Together Against Sizewell C

APPLICATION BY NNB GENERATION COMPANY (SZC) LIMITED
FOR A DCO GRANTING CONSENT FOR THE SIZEWELL C PROJECT

SUMMARY OF ORAL SUBMISSIONS & COMMENTS

RELATING TO ISH 2 and 3 : Traffic and Transport

Green Rail Route (Outside of the Main Development Site Boundary) Plans – Not For Approval

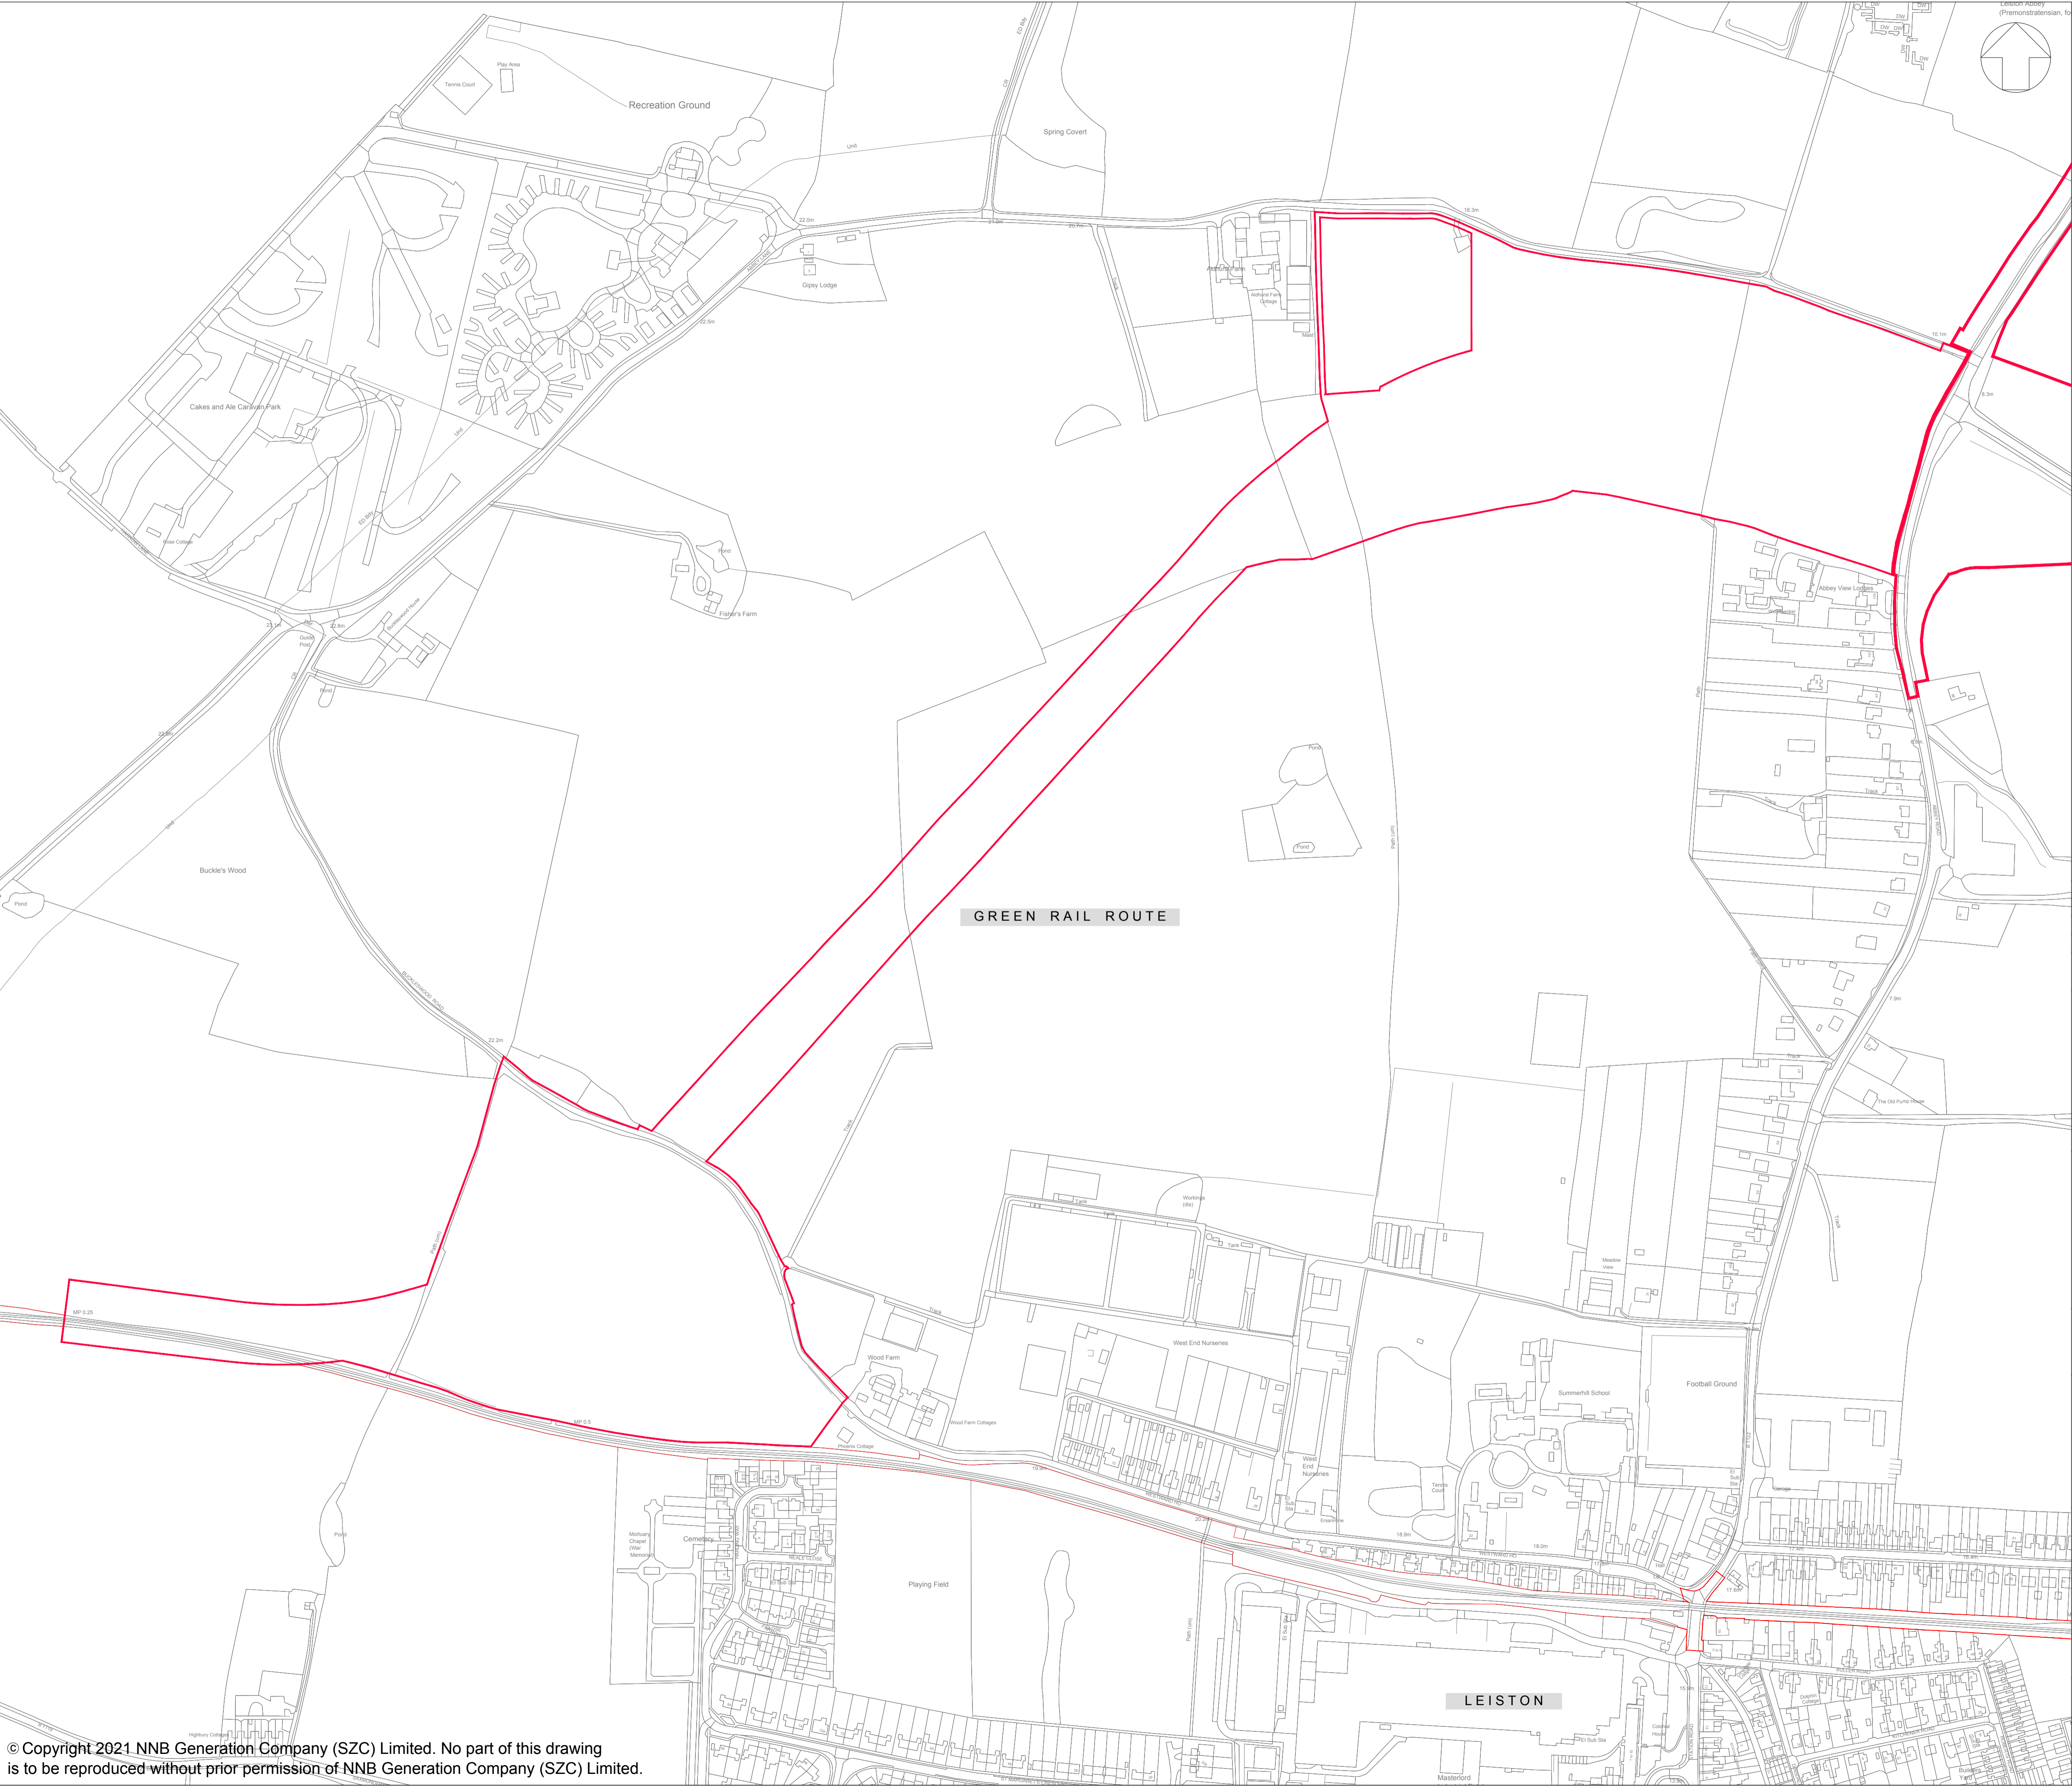
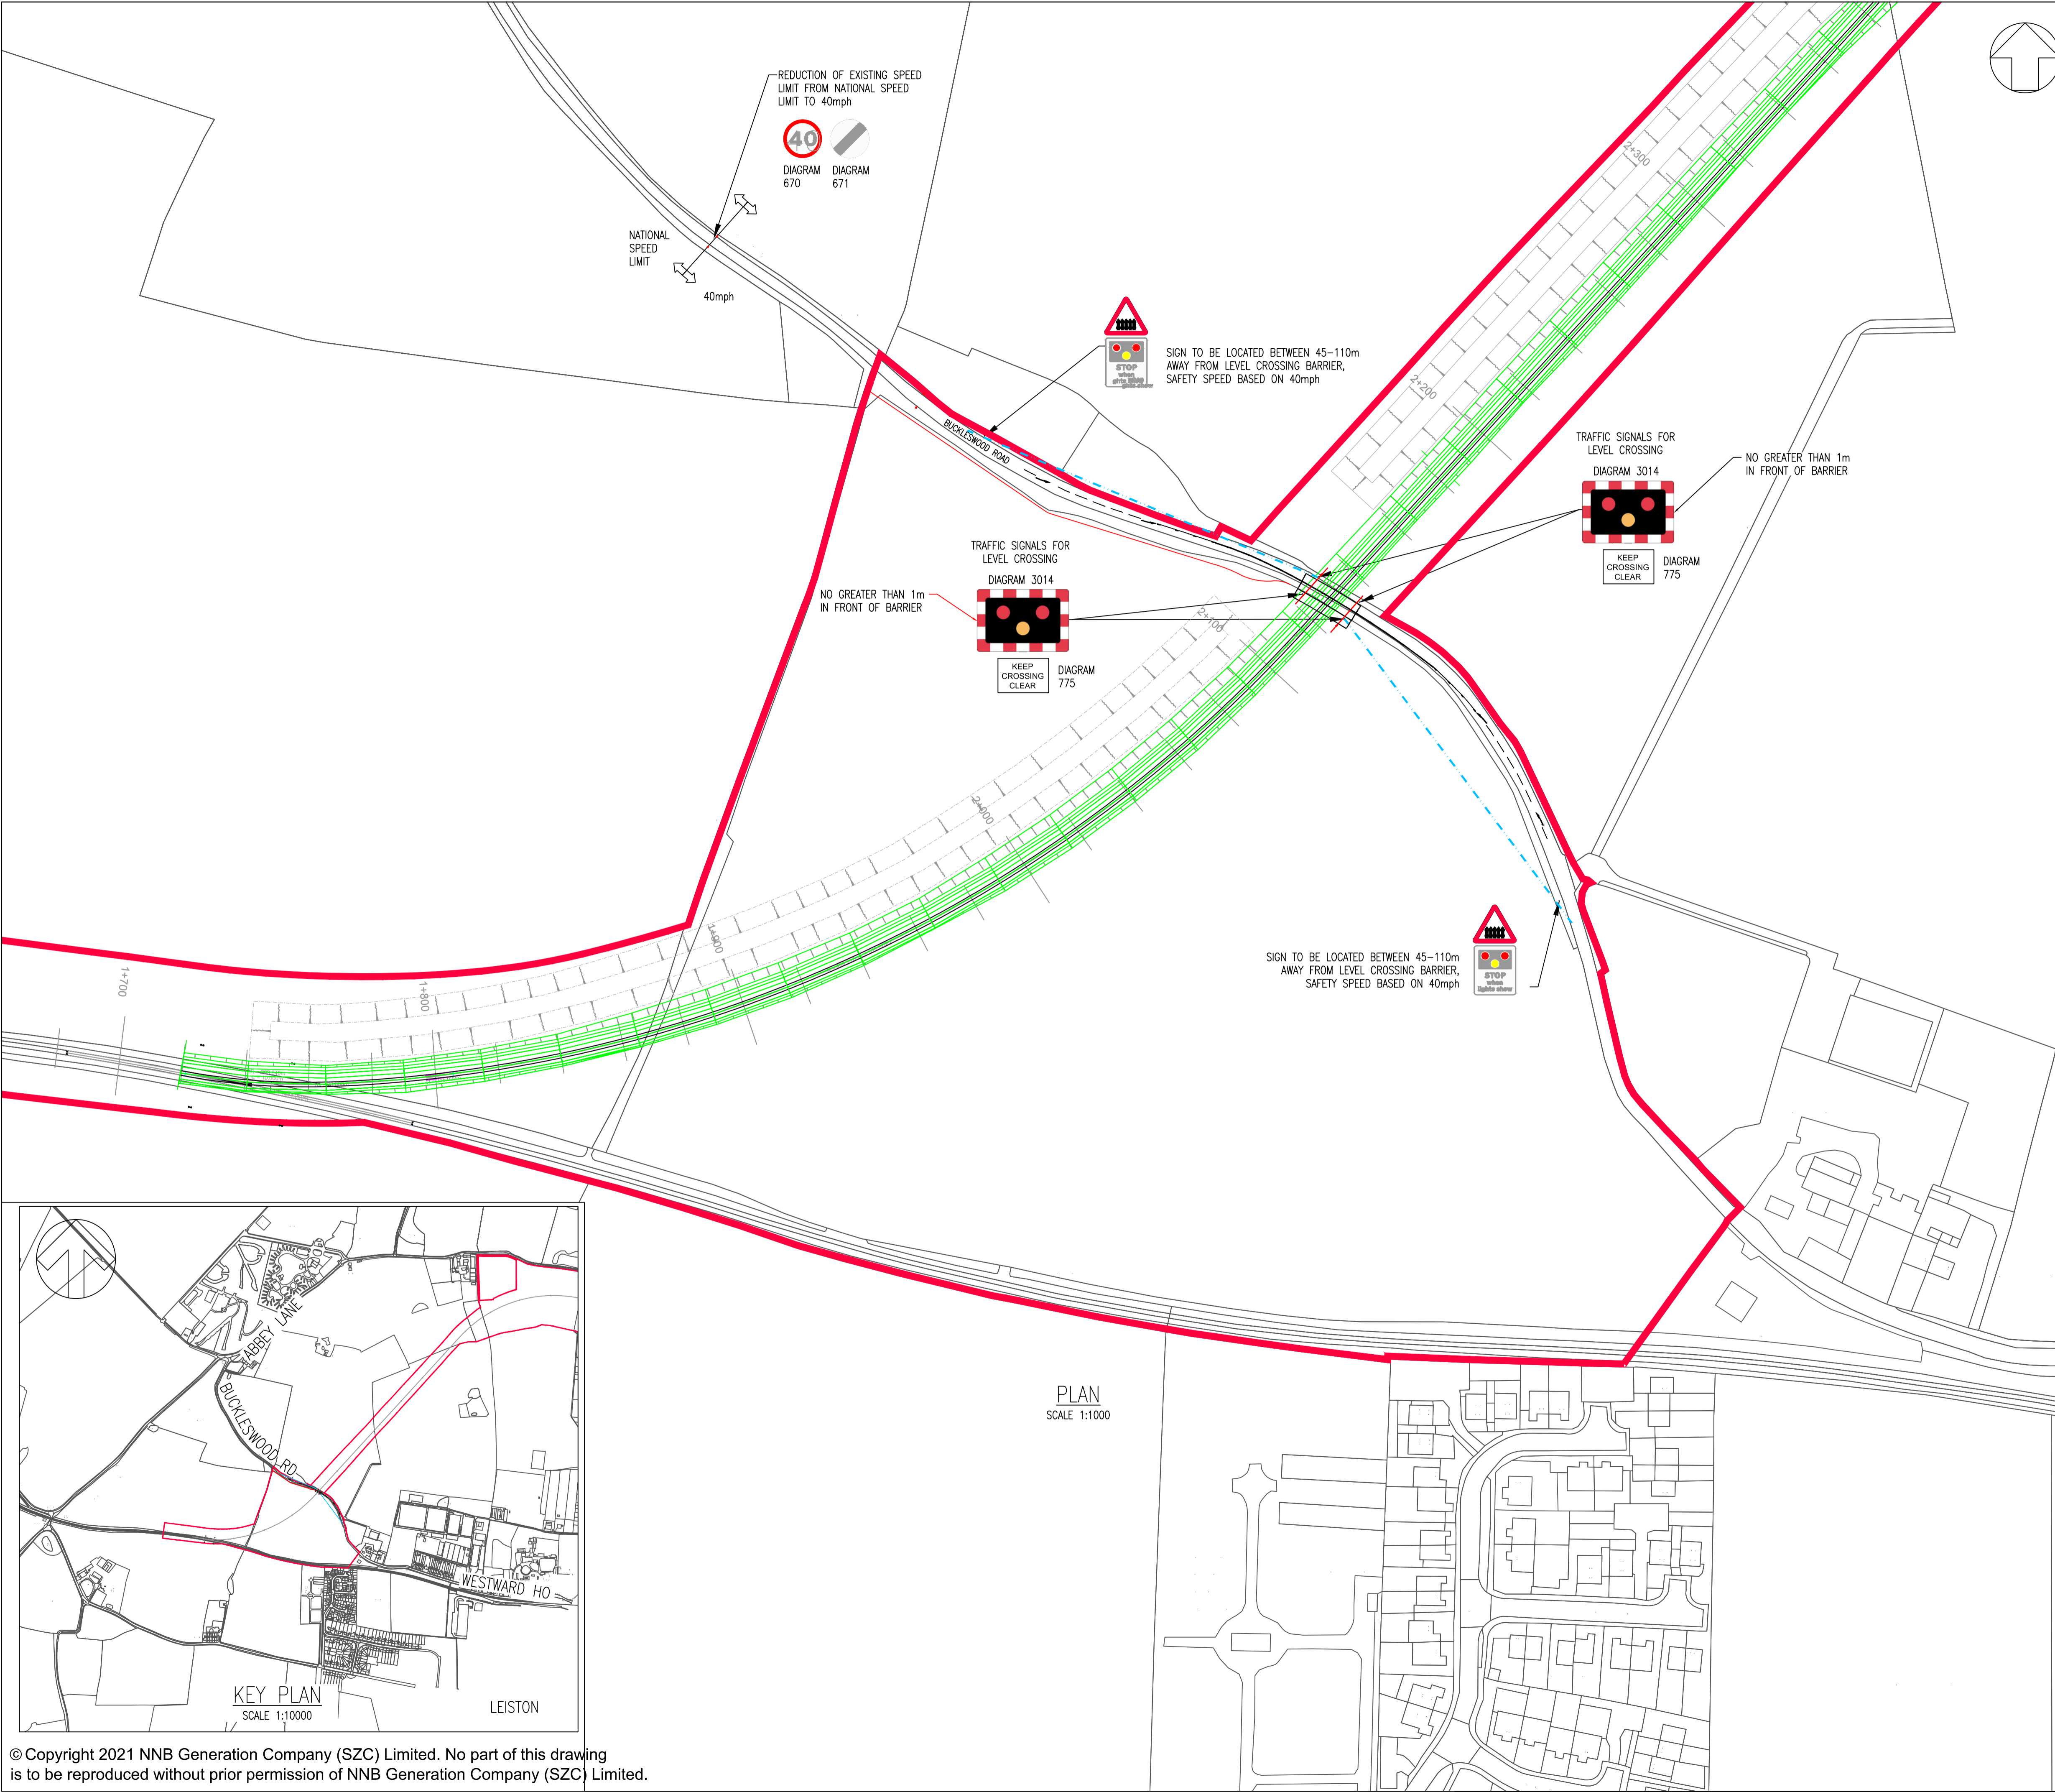
Q.8 11.2.7 Why does the applicant persist in wanting to operate the "Green Rail Route"? The safe and efficient use of the "divisible train staff system" would be better served by the Network Rail signaller at Saxmundham having control of the "Green Rail Route" up to and including the Abbey Road level crossing.
